**Re: McMahon Market Place Lots 9B, 9C, & 9D - 5750 McMahon Blvd NW
Erosion and Sediment Control Plan
Engineer's Stamp Date 11/28/2022 (A11E011I)**

Based upon the information provided in your submittal received on 12/05/2022, the above referenced ESC Plan cannot be approved until the following comments are addressed.

TEMPORARY EROSION AND SEDIMENT CONTROL PLAN

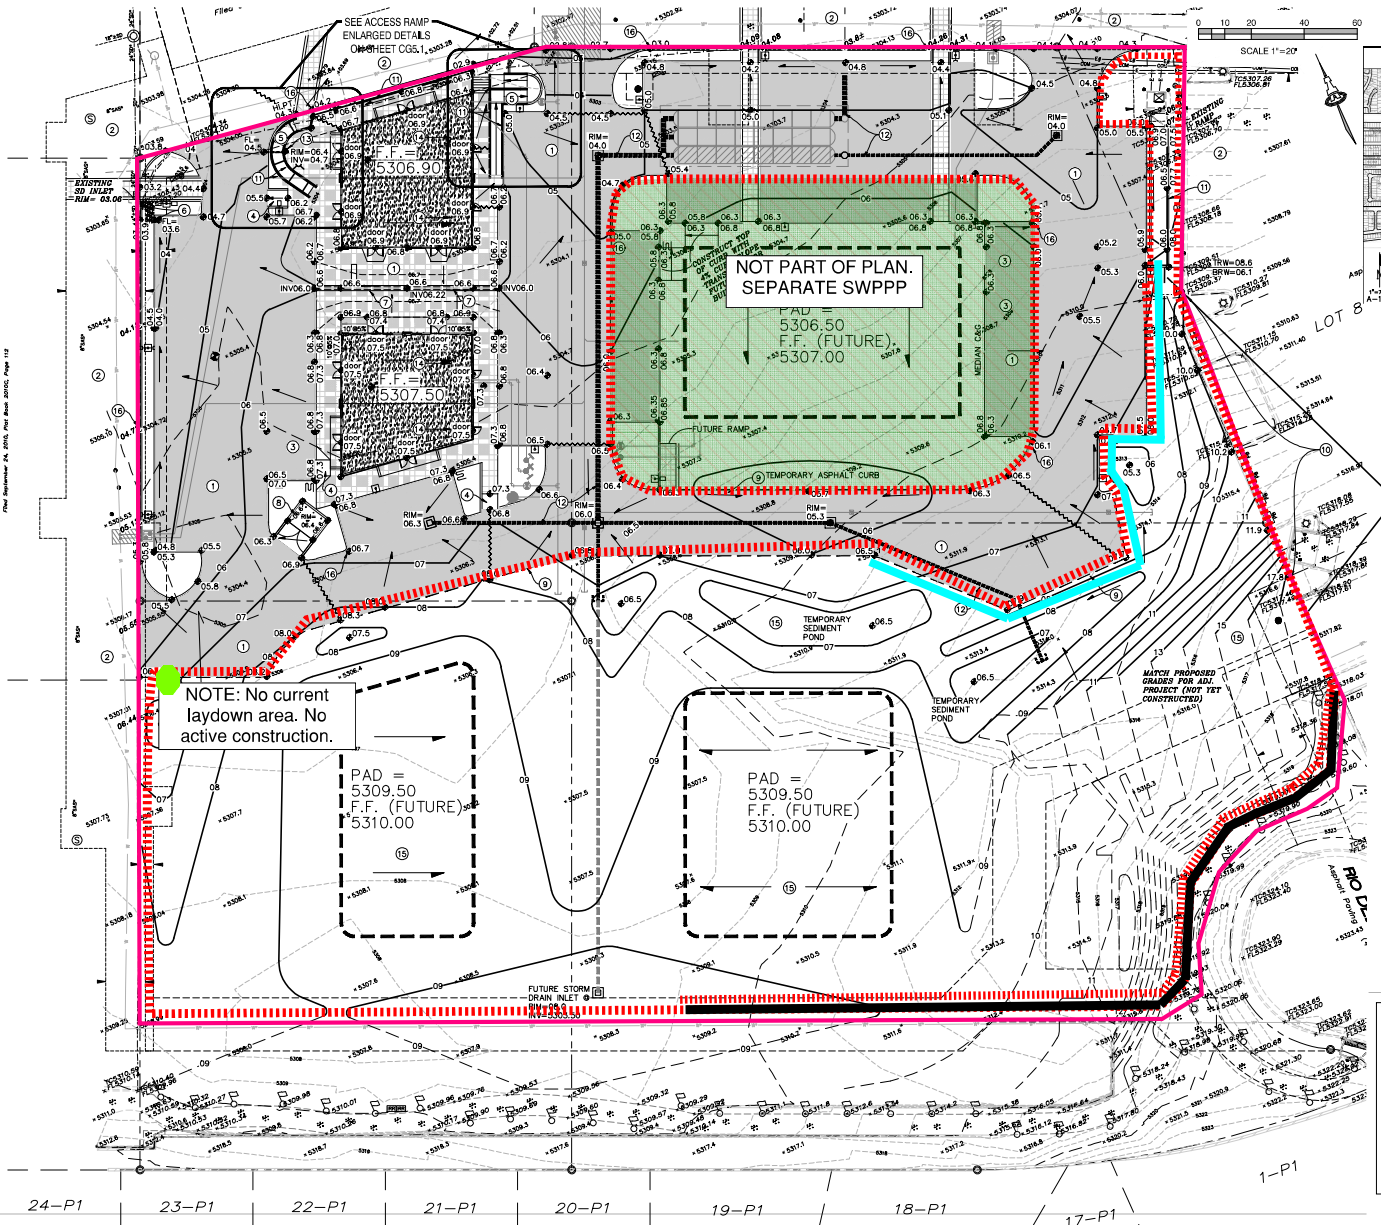
2. The above referenced ESC Plan only covers Lot 9B which may be sufficient for the contractor's area of control but the contractors' plans don't need to be approval by the City. Show all of the remaining disturbed property on the ESC Plan with temporary BMPs and the structures and stabilization that will be provided prior to filing the NOT.

3. Correct the estimated area to be disturbed and the Project /Site Name on the property owner's NOI.
4. The SWPPP must include site-specific interim and permanent stabilization per CGP 9.4.1.c.i. The Landscape Plan can be used to satisfy this requirement and should be submitted separate from the ESC Plan with the application to the Stormwater Quality Section of the Planning Department and they should be included in the SWPPP. Provide a specification on the ESC Plan for any disturbed areas not covered by the Landscape Plan.

5. Describe the nature and extent of construction activities (CGP 7.2.2.). Include the size of the property, and the size of the area of land disturbing activities. Provide a project schedule beginning with the initial establishment of the BMPs, posting of permit coverage, and any demolition covered by the permit. Describe the schedule of stabilization, timing of the removal of the BMPs and filing of the NOT. Describe construction support activities and show staging area on the ESC Plan.
